**Consultation Response from Mike Hibbert,  
KC Waste Strategy( Refuse & Recycling)**

**2022/93397 Highfields Centre, New North Road, Huddersfield, HD1 5LS**

Discharge of conditions 3 (Construction Environmental Management Plan), 4 (cycle parking), 5 (electric vehicle charging), 6 (waste storage and collection), 7 (crime prevention), 8 (materials), 9 (windows schedule), 10 (boundary treatments), 11 (external lighting), 12 (sound insulation), 13 (site investigation), 14 (phase II site investigation), 18 (landscaping), 19 (Ecological Design Strategy) and 21 (tree protection) of previous Section 73 approval 2021/92291 for conversion of former college buildings into 33 apartments including demolition of link canopy, partial demolition of link building, erection of additional storey to link building, and internal and external alterations

**Responding Ref: WPS 24-065**

**Drawing Title:** Proposed Ground Floor Plan: Building A and toilet block and all floors: Link and Tower Buildings

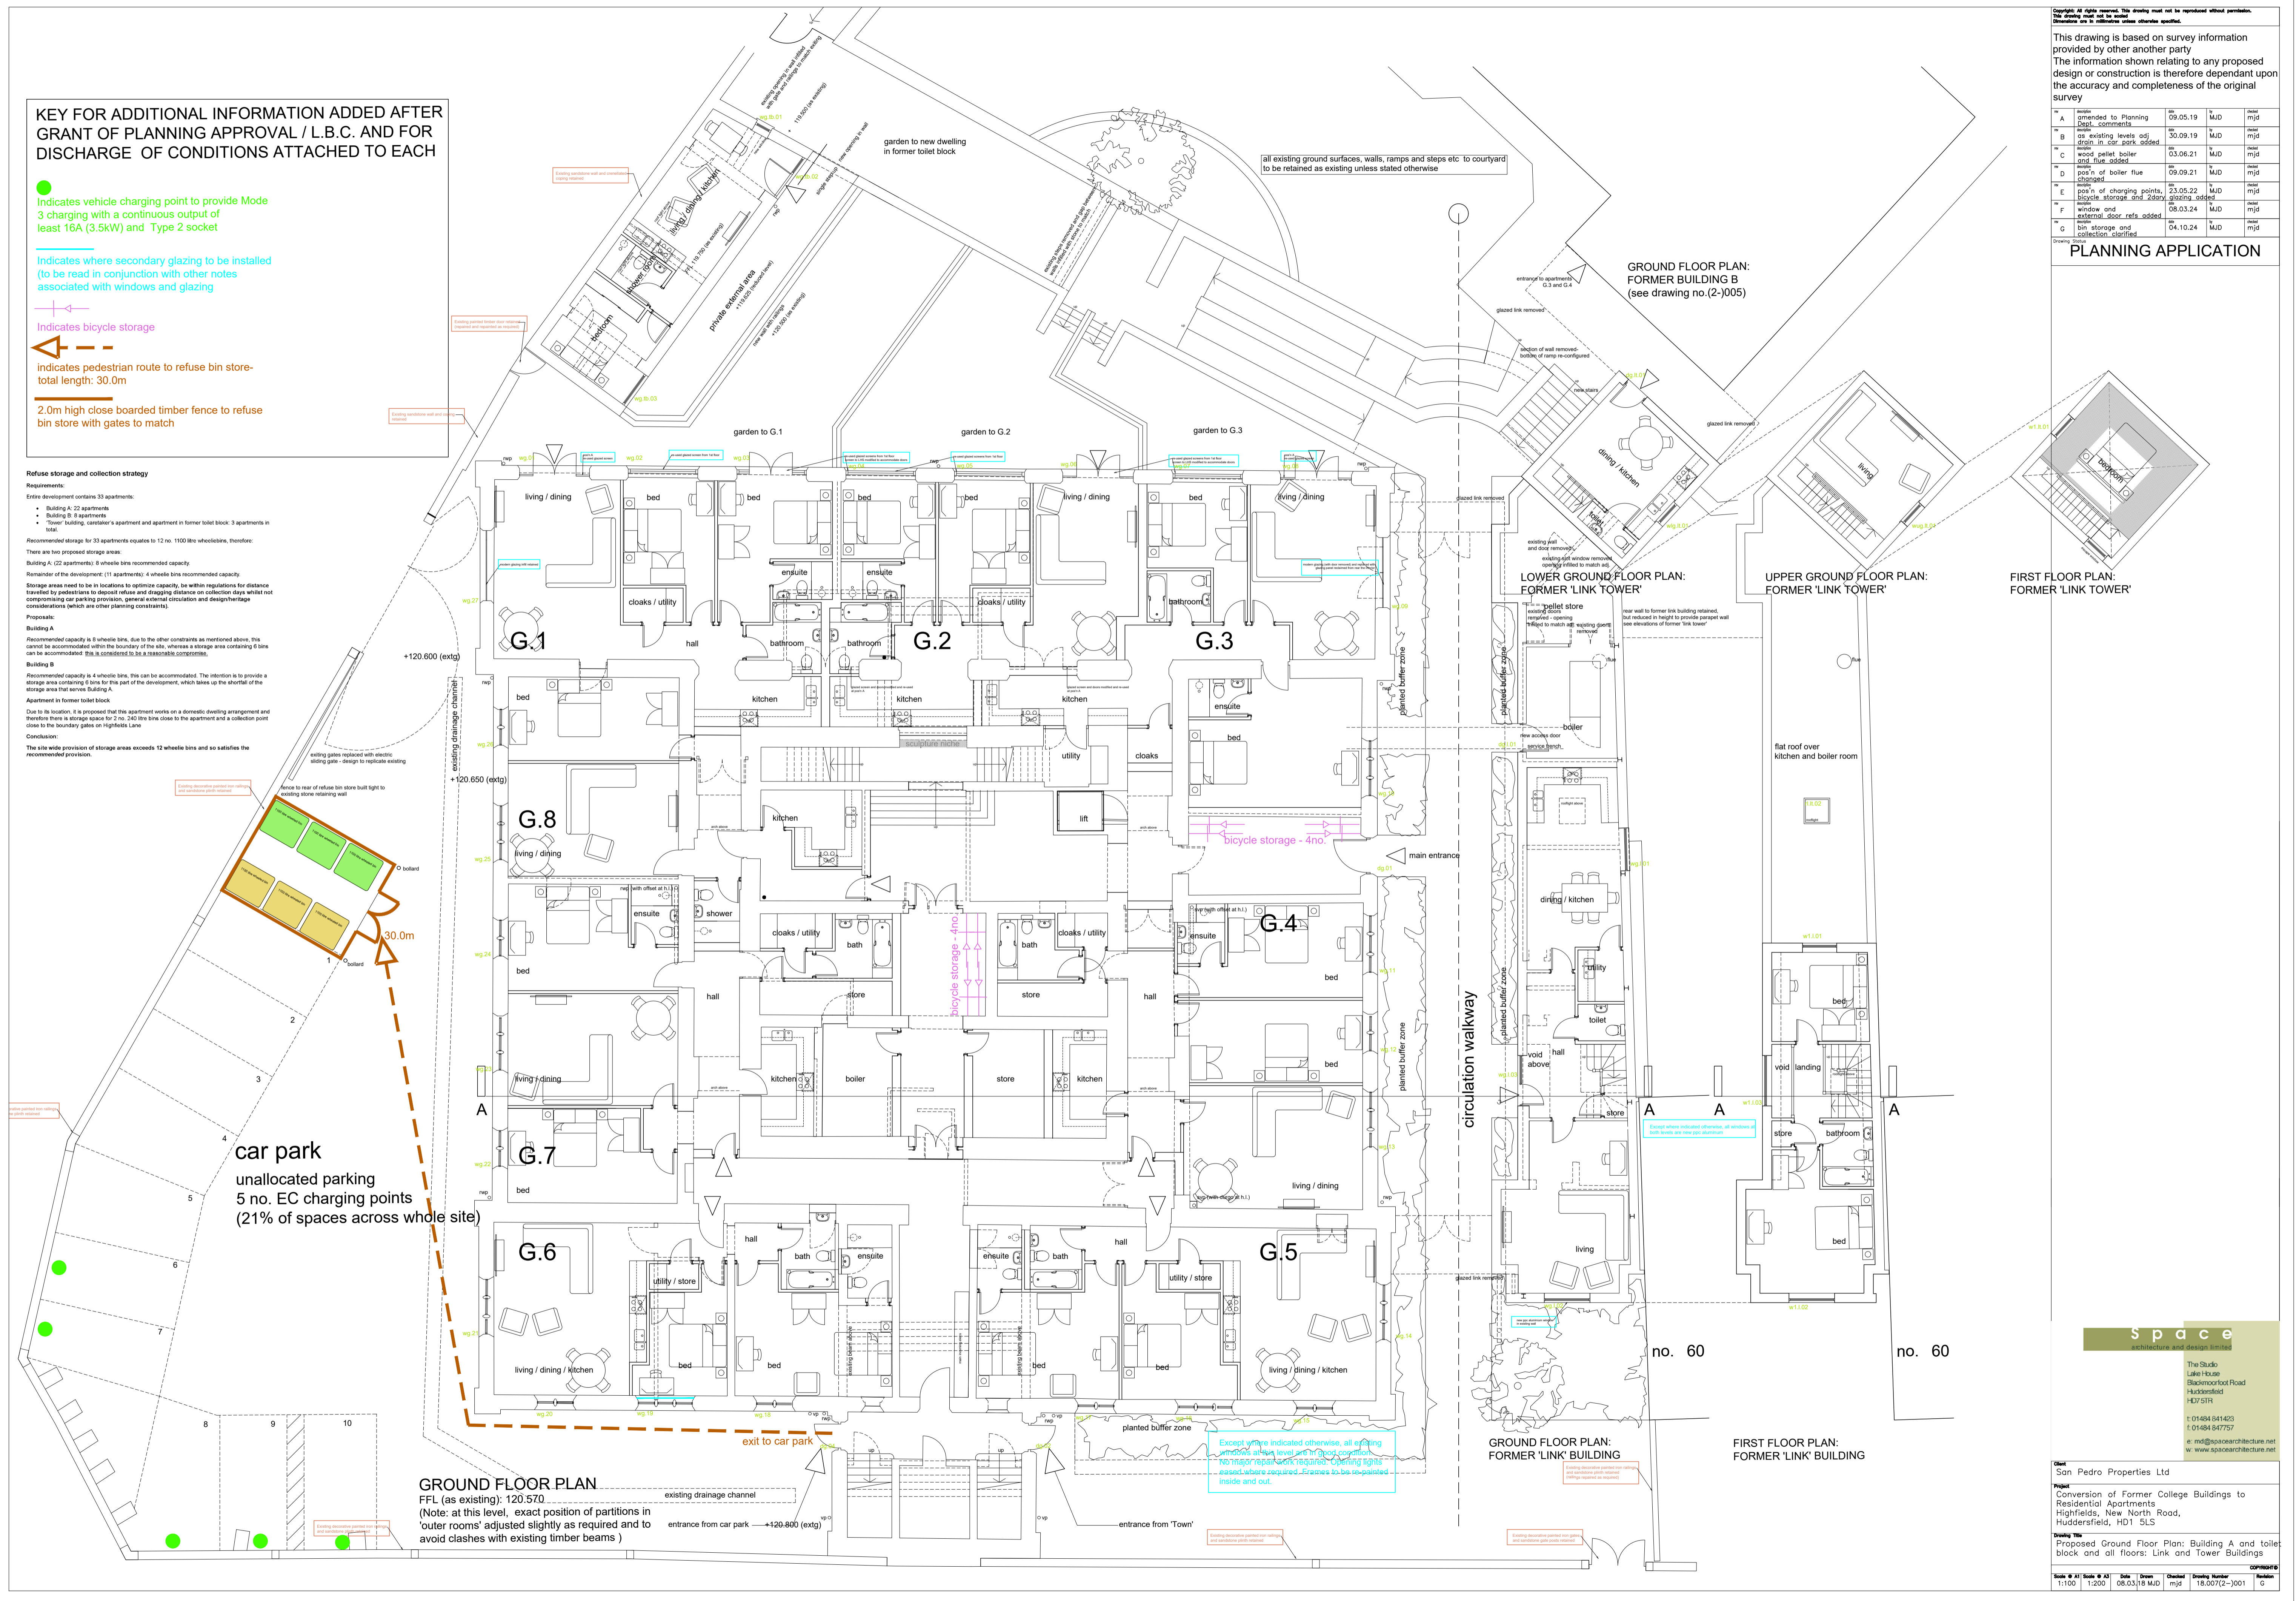
The applicant has submitted Proposed Site Layout Plan Dwg No. 18.007(9)-008 Rev E dated 4/10/24 that is annotated to show the location and dimensions of bin stores for Buildings A, B and former Toilet Block.

The stores are screened with 2.0m close boarded timber fence with gates to match.

*Recommended* capacity is 8 wheelie bins, due to the other constraints as mentioned above, this cannot be accommodated within the boundary of the site, whereas a storage area containing 6 bins can be accommodated: this is considered to be a reasonable compromise.

*Recommended* capacity is 4 wheelie bins, this can be accommodated. The intention is to provide a storage area containing 6 bins for this part of the development, which takes up the shortfall of the storage area that serves Building A.

Due to its location, it is proposed that this apartment works on a domestic dwelling arrangement and therefore there is storage space for 2 no. 240 litre bins close to the apartment and a collection point close to the boundary gates on Highfields Lane

**The site wide provision of storage areas exceeds 12 wheelie bins and so satisfies the *recommended* provision.**

**The submitted plans and strategy are acceptable and therefore the WCA has no objection to Discharge of Condition 6.**
